Our reference:  
DCO/2018/00016

### **The Planning Act 2008, AQUIND Limited, proposed AQUIND Interconnector Project Deadline 6 Response**

This document comprises the MMO comments in respect of the Examining Authority’s (ExA’s) further written questions (ExQ2), received by MMO on 7 January 2021. Please see Annex 1 of this document for MMO’s comments.

Drawing file: EN020022 / EN020022-000605-6.2.3.7 ES - Vol 2 - Figure 3.7 Atlantic Cable Crossing.pdf

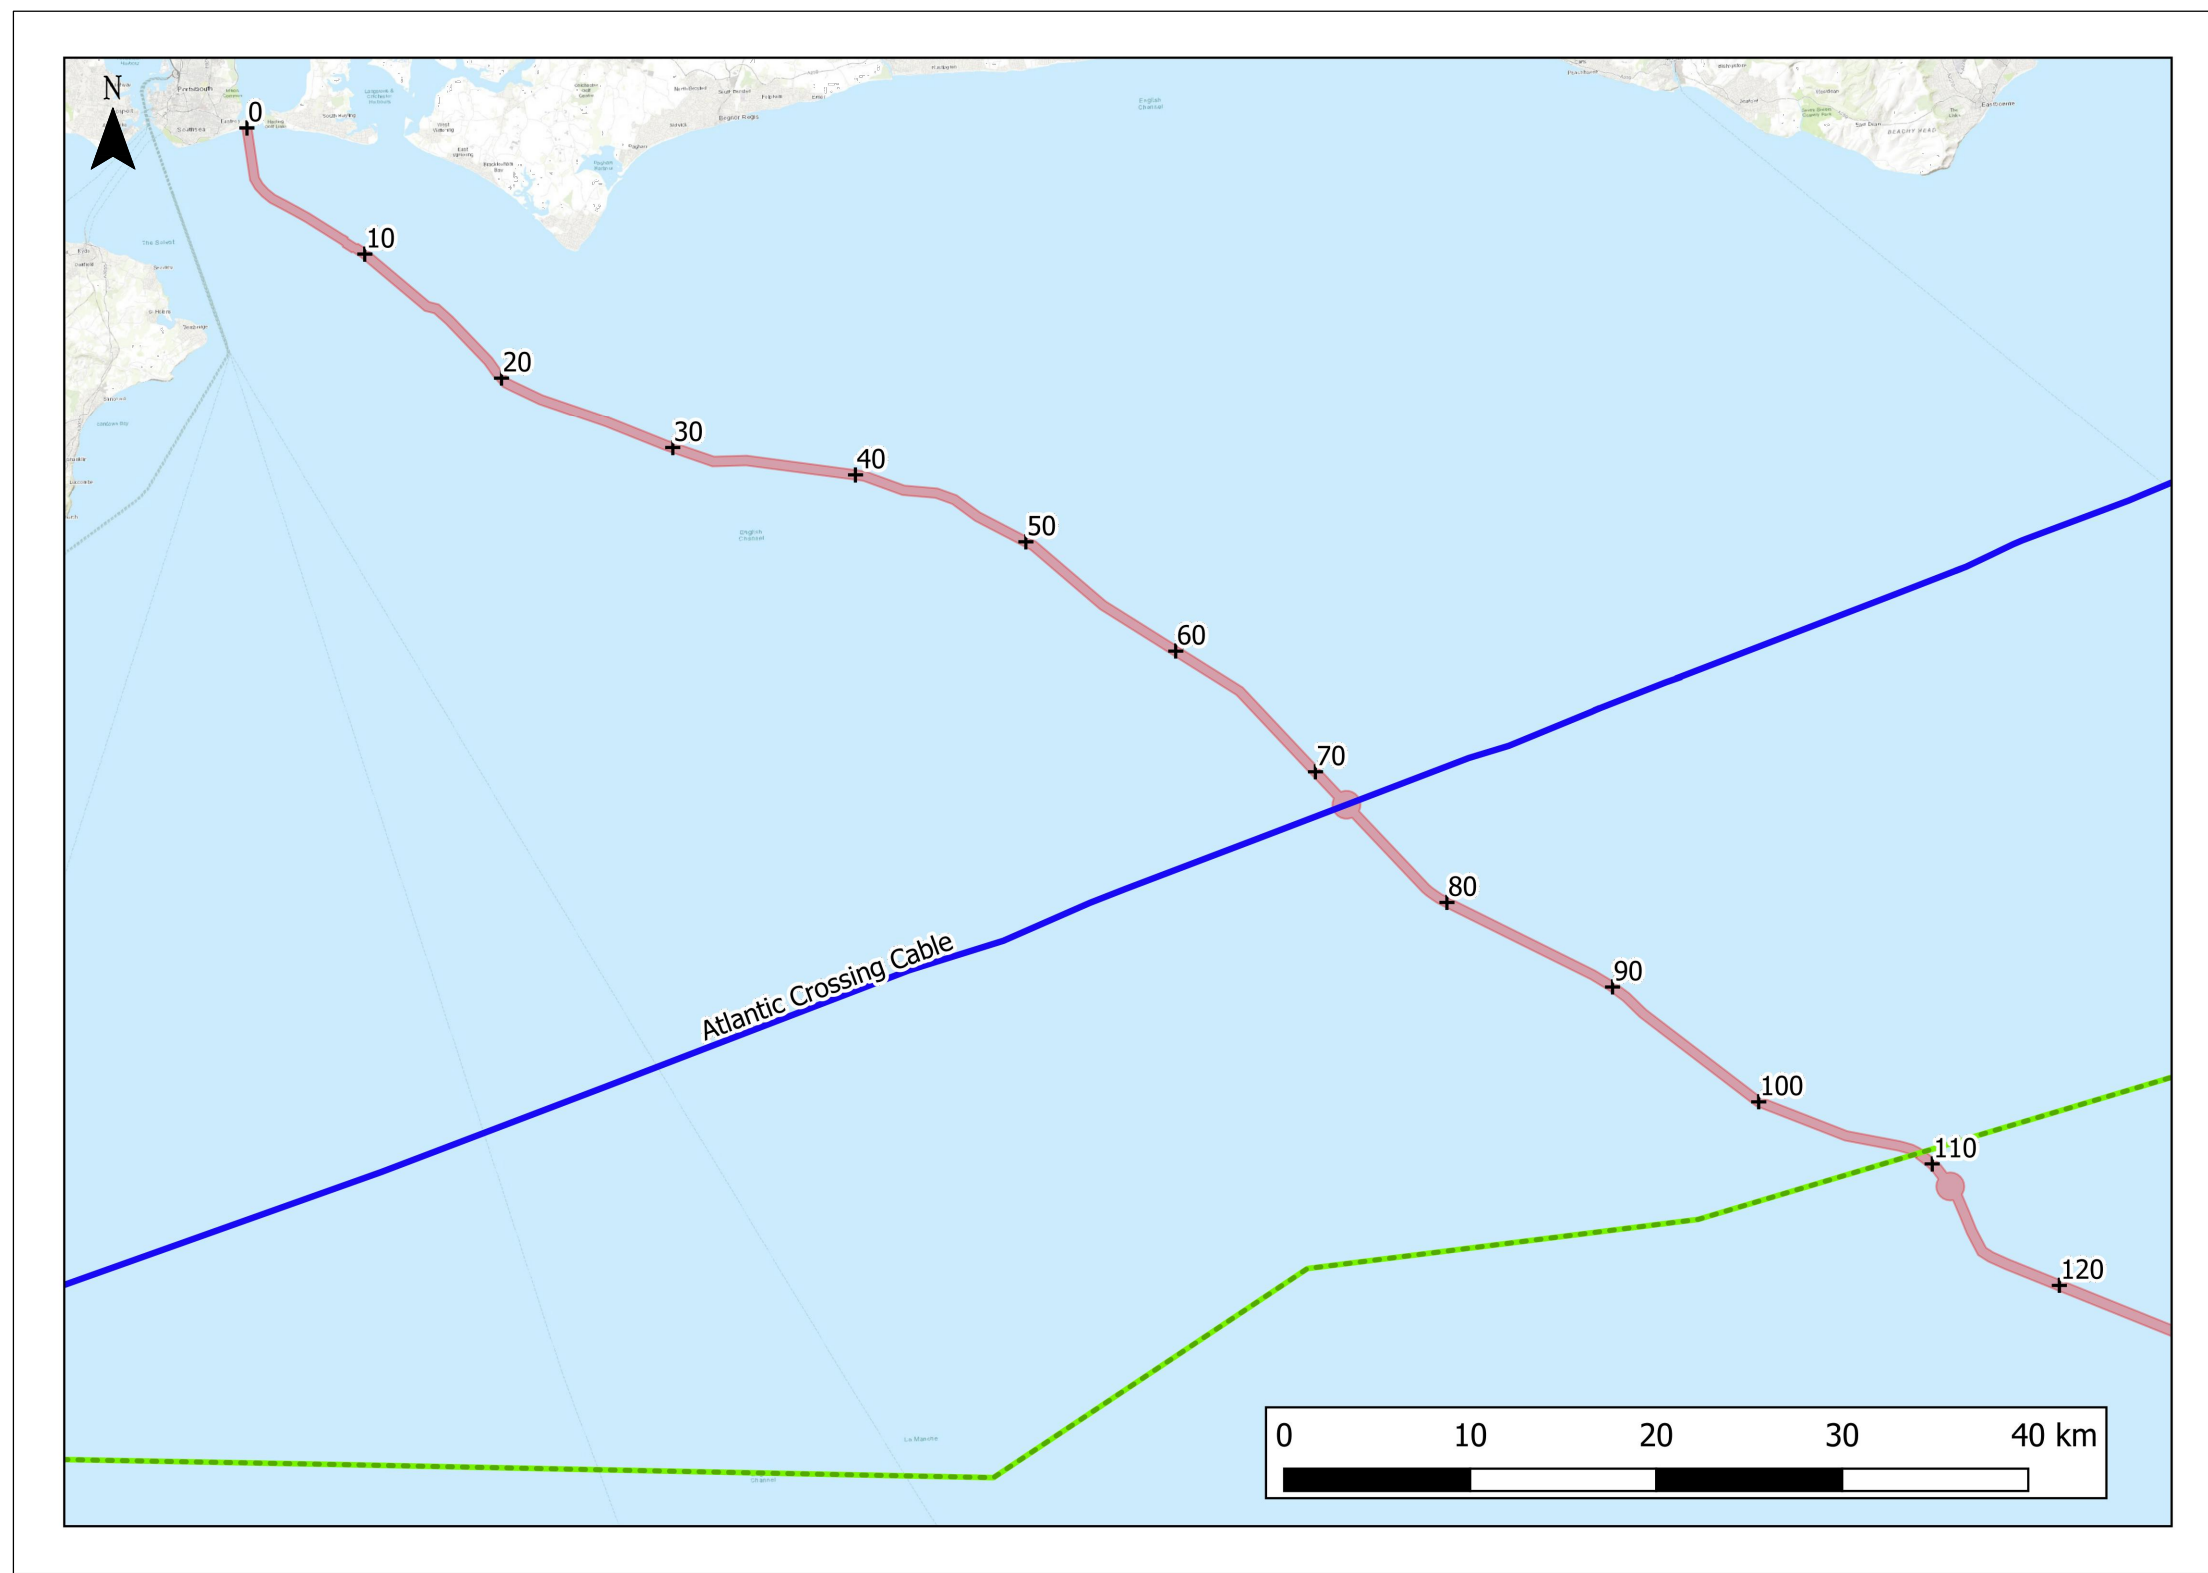
ME2.10.4	Applicant MMO	We understand that the Applicant and MMO have reached agreement on the definition, detail and monitoring of the Atlantic cable crossing at Part 1 (4) (1) of the DML but that the MMO has some residual concerns regarding the details in Part 1 (4) more broadly. Have these concerns been overcome and, if so, how?	As per the MMO's response to DCO 2.5.2, the MMO understand that the intent of this paragraph is to authorise licensable marine activities which would be considered further development. However, the word 'authorise' is not included in the wording. This is an observation by MMO and not an objection. MMO are content with the rest of the wording.
ME2.10.5	Applicant MMO	Have the MMO and the Applicant reached agreement on the need for resampling of sediments for contamination at the offshore HDD entry/ exit point if these works do not occur within 5 years from the date of the latest contaminant analysis? If not, has an agreed form of wording for a DML condition been agreed, notwithstanding the Applicant's view that it should not be applied?	MMO maintain the position that this resampling condition will be required. The Applicant has requested examples of other cases where this has been applied. The MMO makes decisions on a case by case basis and no two cases are the same. The MMO issues a large number Marine Licences every year and will not be reviewing them in order to find an example of this condition, as every project is different and assessed on its own merit. MMO have followed OSPAR guidance and Cefas advice and are confident that this condition is required.
